WELWYN HATFIELD BOROUGH COUNCIL – DEVELOPMENT MANAGEMENT
DELEGATED REPORT

APPLICATION No: N6/2014/0539/FP

SITE ADDRESS: 7 Densley Close, Welwyn Garden City

DESCRIPTION OF DEVELOPMENT: Erection of two, two storey side extensions

Drawing Title: PROPOSED PLANS AND ELEVATIONS

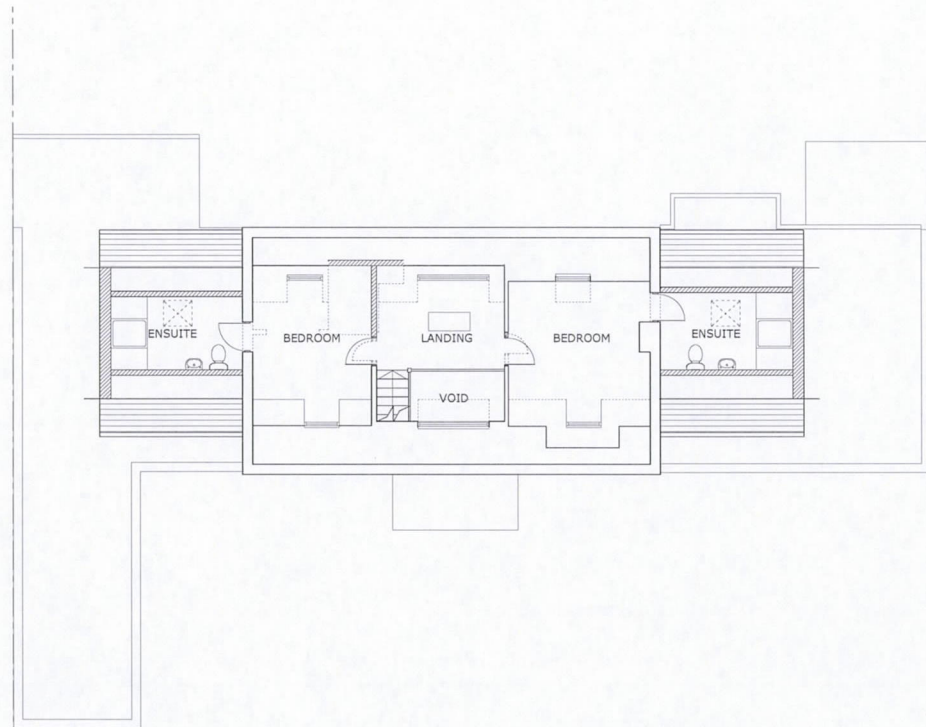
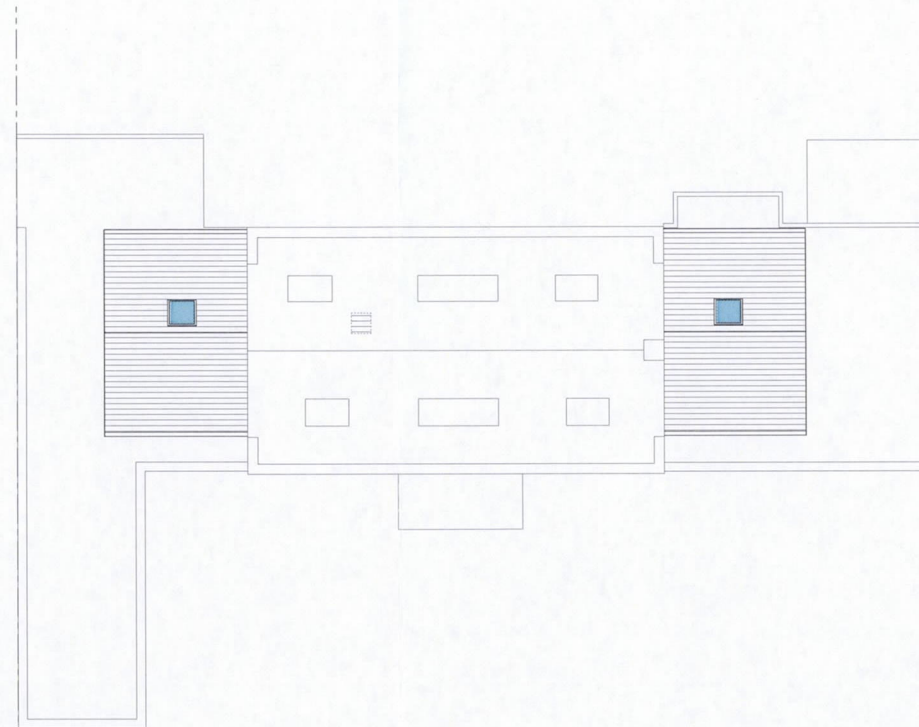
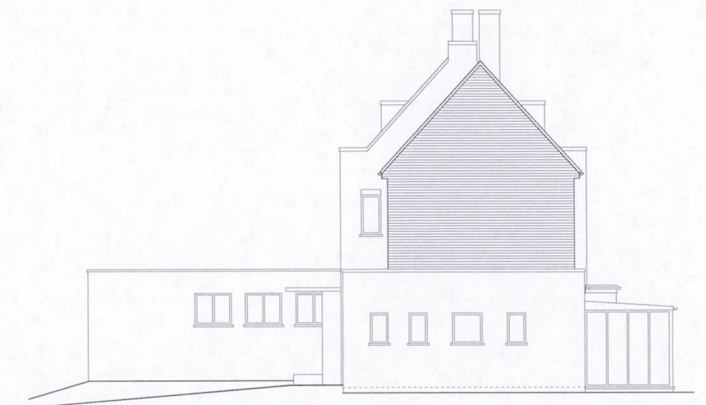
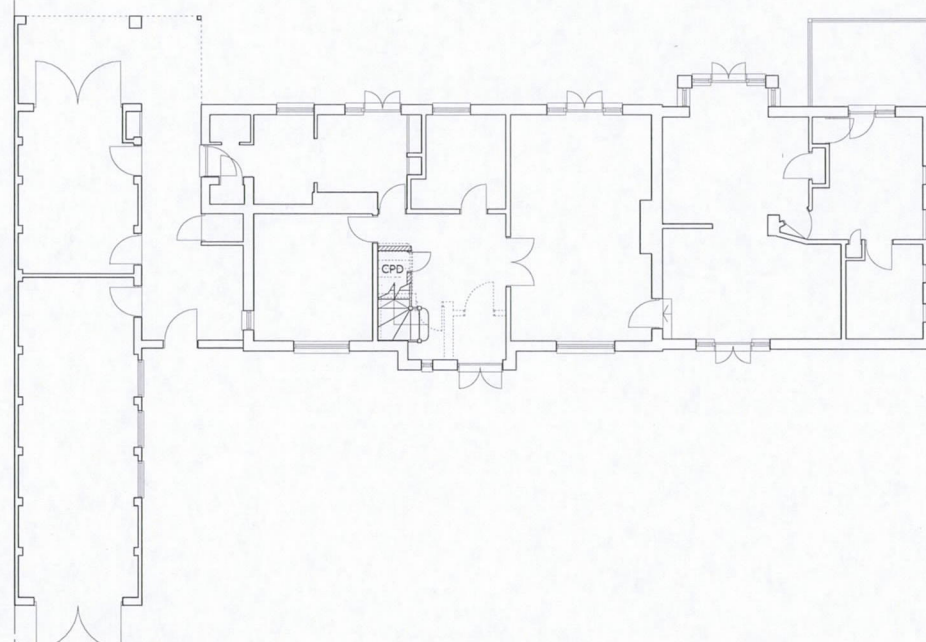
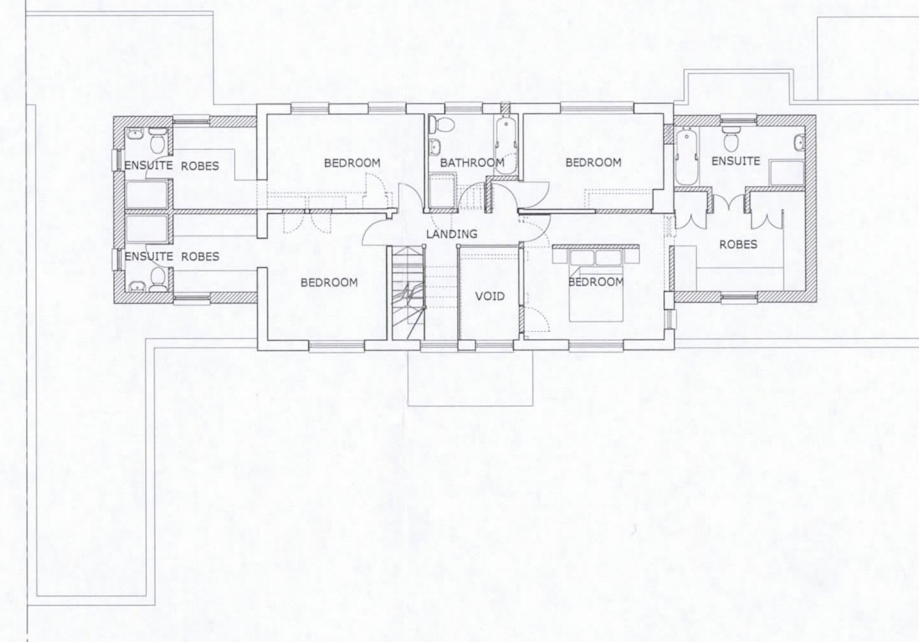
The proposal seeks planning permission for a 3.9m wide extension either side of the existing dwelling at first floor above the existing single storey side extensions incorporating a pitched roof above. The pitched roof will be set below the ridgeline of the main roof by approximately 0.5m. The proposed first floor side extension will provide three ensembles and walk-in wardrobes. The proposed pitched roof will also provide two additional ensembles with a roof light upon the rear roof slope of both side extensions.

Whilst a minimum of 2.35m separation space will exist at first floor level along the shared boundary with No.5 Densley Close and at least 4.8m at first floor level with 19 Scholars Mews, the proposed side extensions at 3.9m wide are considered to add additional bulk to the existing dwelling which would fail to appear as subordinate in scale and design to the existing dwelling. Furthermore, the proposed set back from the front elevation of the existing dwelling by approximately 1.3m is not considered a sufficient enough set back to appear subordinate in scale, creating side extensions of approximately 5.1m in depth.

Paragraph 5.2 (i) of the supplementary design guidance states that, '*extensions should be designed to complement and reflect the design and character of the dwelling*'. A projecting flat roof design feature exists on both the front and rear elevation of the existing dwelling and therefore the eaves design of the proposed side extensions would fail to appropriately reflect the eaves design of the existing dwelling to the detriment of the design and character of the existing dwelling.

To conclude, the scale and design of the proposed side extensions would add additional bulk to the side of the dwelling that would fail to appear subordinate in scale to the existing dwelling and would be visually prominent within the streetscene to the detriment of the character and appearance of the Conservation Area. Furthermore, the eaves design of the proposed side extensions would fail to appropriately reflect the eaves design of the existing dwelling to the detriment of the design and character of the existing dwelling. Overall, the proposal would fail to represent high quality design and is therefore contrary to paragraph 131 of the National Planning Policy Framework and Policies D1 and D2 of the Welwyn Hatfield District Plan, 2005.

The scale and design of the proposed side extensions would fail to represent high quality design by adding additional bulk to the side of the dwelling that would fail to appear subordinate in scale to the existing dwelling and would be visually prominent within the streetscene by virtue of their width and depth. Furthermore, the eaves design of the proposed side extensions would fail to appropriately reflect the eaves

design of the existing dwelling to the detriment of the design and character of the existing dwelling. The proposal would therefore fail to sustain or enhance the character and appearance of the Conservation Area contrary to paragraph 131 of the National Planning Policy Framework and Policies D1 and D2 of the Welwyn Hatfield District Plan and the Supplementary Design Guidance; Statement of Council Policy 2005.

1. The scale and design of the proposed side extensions would add additional bulk to the side of the dwelling that would fail to appear subordinate in scale to the existing dwelling and would be visually prominent, by virtue of their width and depth, to the detriment of the character and appearance of the streetscene. Furthermore, the eaves design of the proposed side extensions would fail to appropriately reflect the eaves design of the existing dwelling to the detriment of the design and character of the existing dwelling. The proposal would therefore fail to represent high quality design and would fail to sustain or enhance the character and appearance of the Conservation Area contrary to paragraph 131 of the National Planning Policy Framework and Policies D1 and D2 of the Welwyn Hatfield District Plan and the Supplementary Design Guidance; Statement of Council Policy 2005.
